Our Ref: EN010088

Date: 9 March 2020

Application by EDF Energy (Thermal Generation) Limited for an Order Granting Development Consent for the West Burton C power station

Request for further information from the Applicant, Bassetlaw District Council, West Lindsey District Council and Natural England

Drawing Title
**FIGURE 4.2a
INDICATIVE ELEVATIONS -
SINGLE LARGE GAS TURBINE**

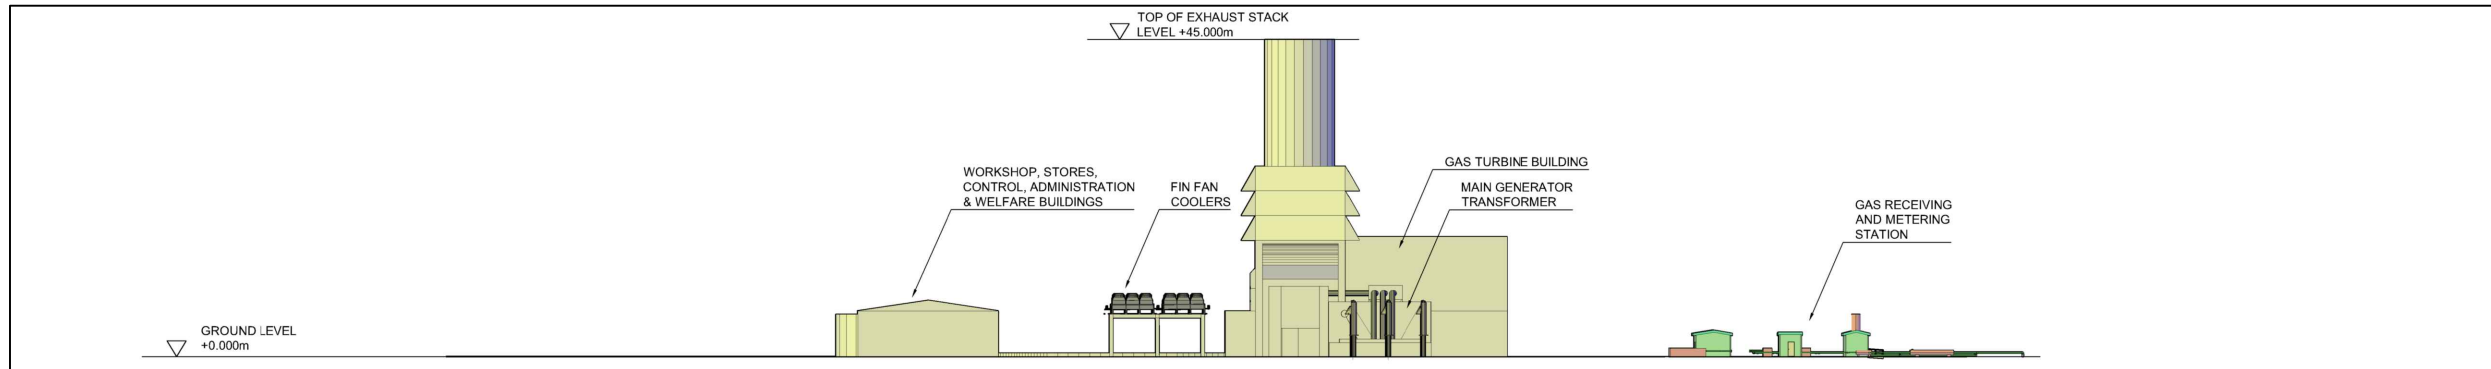
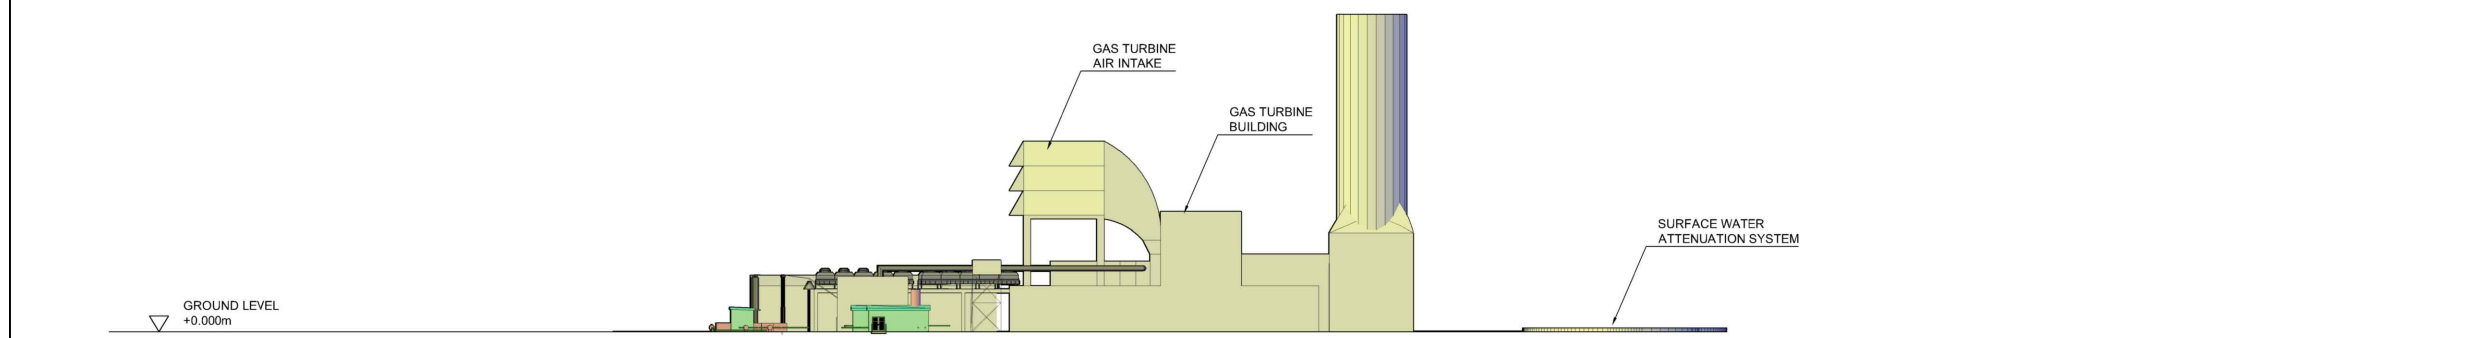
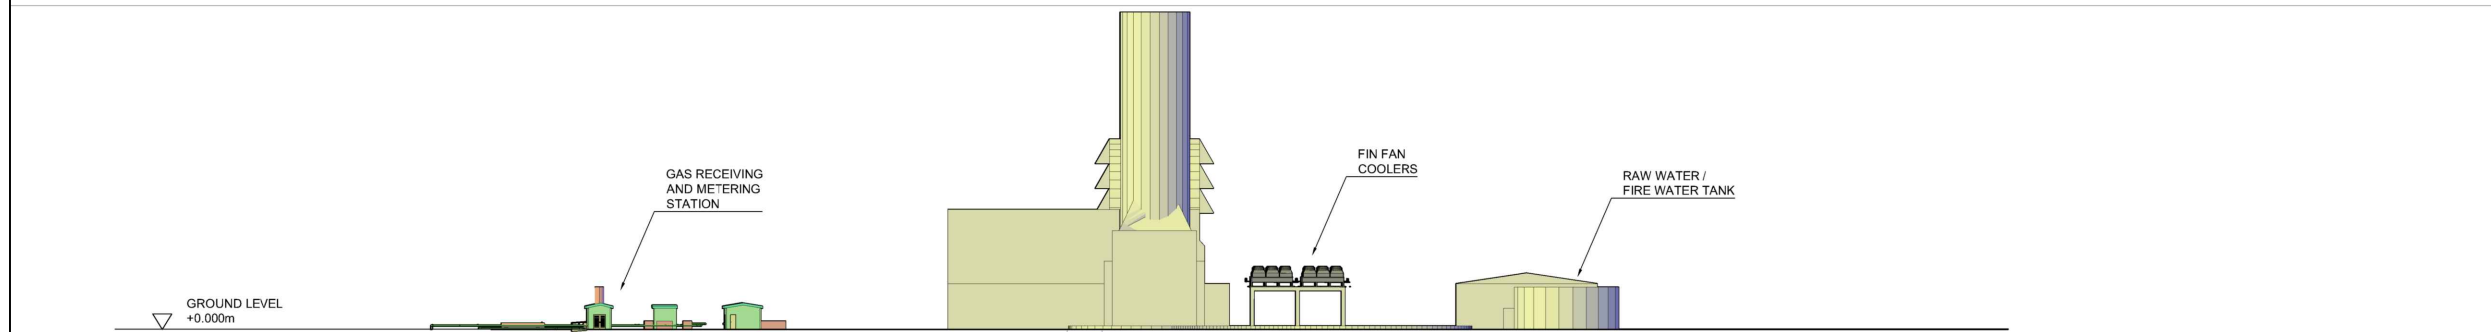
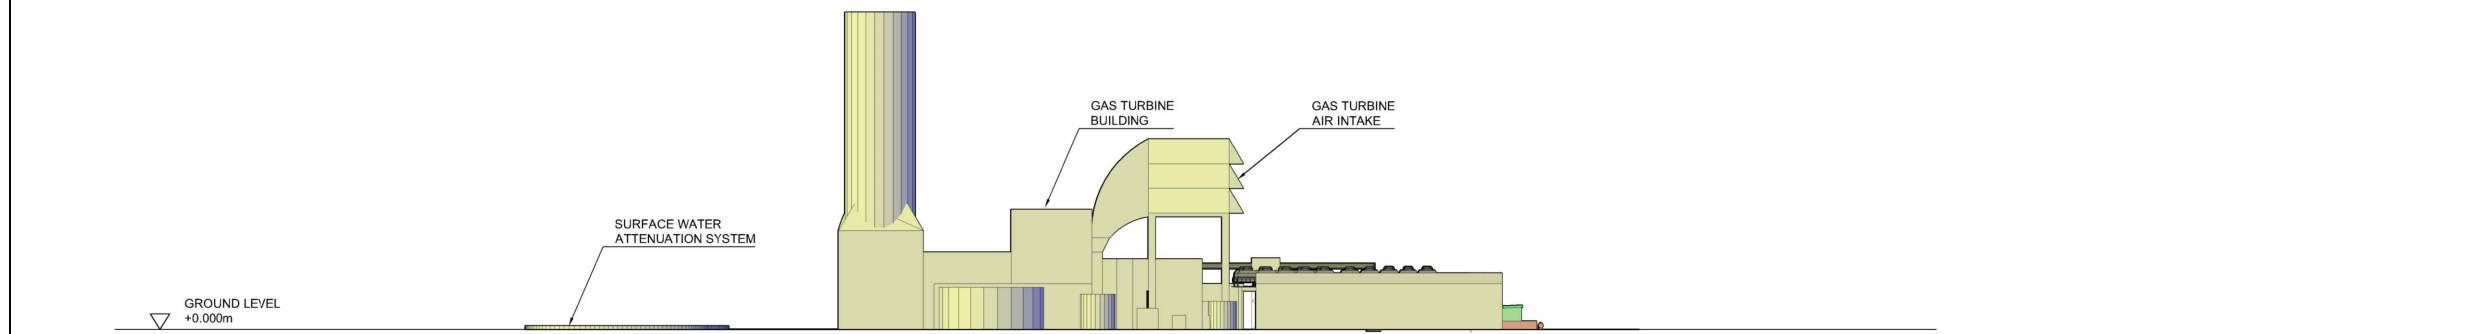
Paragraph 6.5.6 of ES Chapter 6 [APP-035] sets out that 'Emission to air impacts have been assessed based on 35m stack heights (for each of up to five unit stacks) and 40m stack height (for a single gas turbine stack) based on height above finished ground level. These are the stack heights considered to adequately disperse emissions from the Proposed Development assessed options.' Table 1 of Requirement 5 of the dDCO provides for maximum stack heights of 59m Above Ordnance Datum (AOD) which has been assessed in visual impact terms. However, the dDCO should reflect all assessments in the ES.

Therefore, **the Applicant** is requested, for clarity, to ensure that Table 1 of Requirement 5 of the dDCO includes all relevant stack height parameters corresponding to the Environmental Impact Assessment undertaken, including minimum and maximum heights, in terms of both Above Ground Level (AGL) and AOD.

Drawing Title
**VIEWPOINT 4 - WIREFRAME (WINTER)
 SINGLE LARGE GAS TURBINE
 PLANAR PROJECTION**

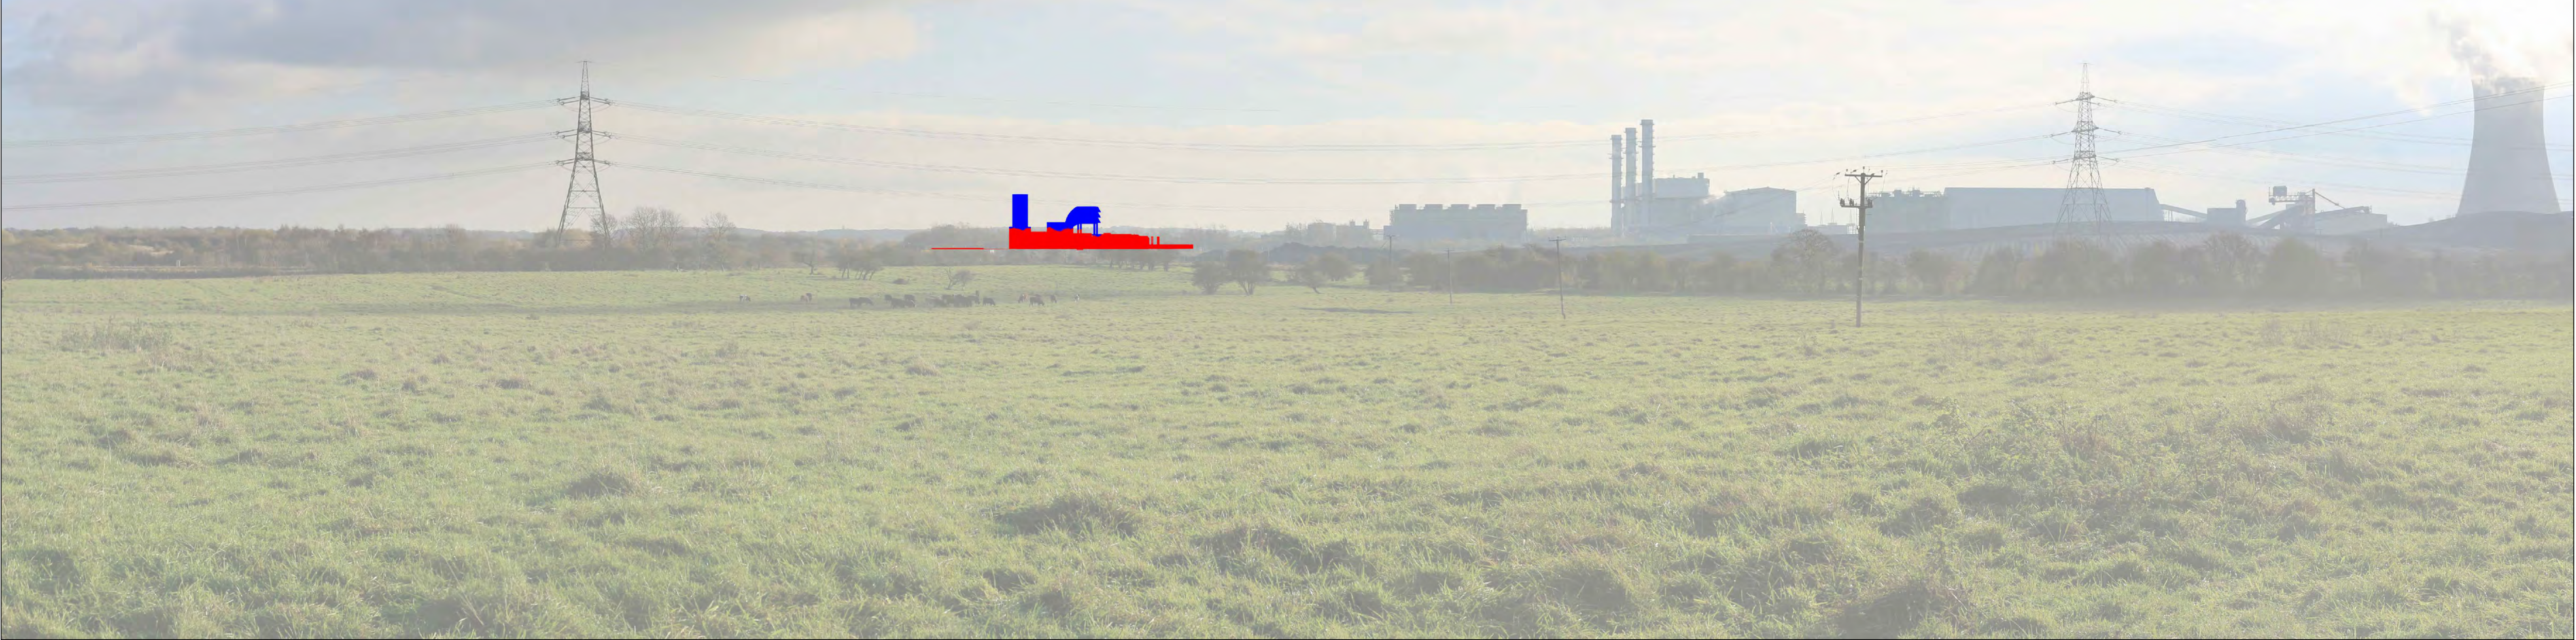
Paragraph 10.3.28 of ES Chapter 10 [APP-039] states that a north-south configuration of multiple stacks would have a greater visual effect than an east-west configuration. Paragraph 4.3.3 of ES Chapter 4 [APP-033] sets out that certain parameters have been fixed, including that 'if multiple turbines are installed, the units (and stacks) are located in a nominal north-south orientation'. However, paragraph 4.3.9 of ES Chapter 4 states that 'The exact positions of the OCGT stack(s) cannot be fixed until the detailed design stage as they will depend on the final technical configuration and plant optimisation'. The dDCO also does not appear to secure a configuration if multiple stacks were to be used which suggests that an east-west configuration, with lesser visual impact, could be adopted in any final design. Can **the Applicant** provide clarification on these matters?
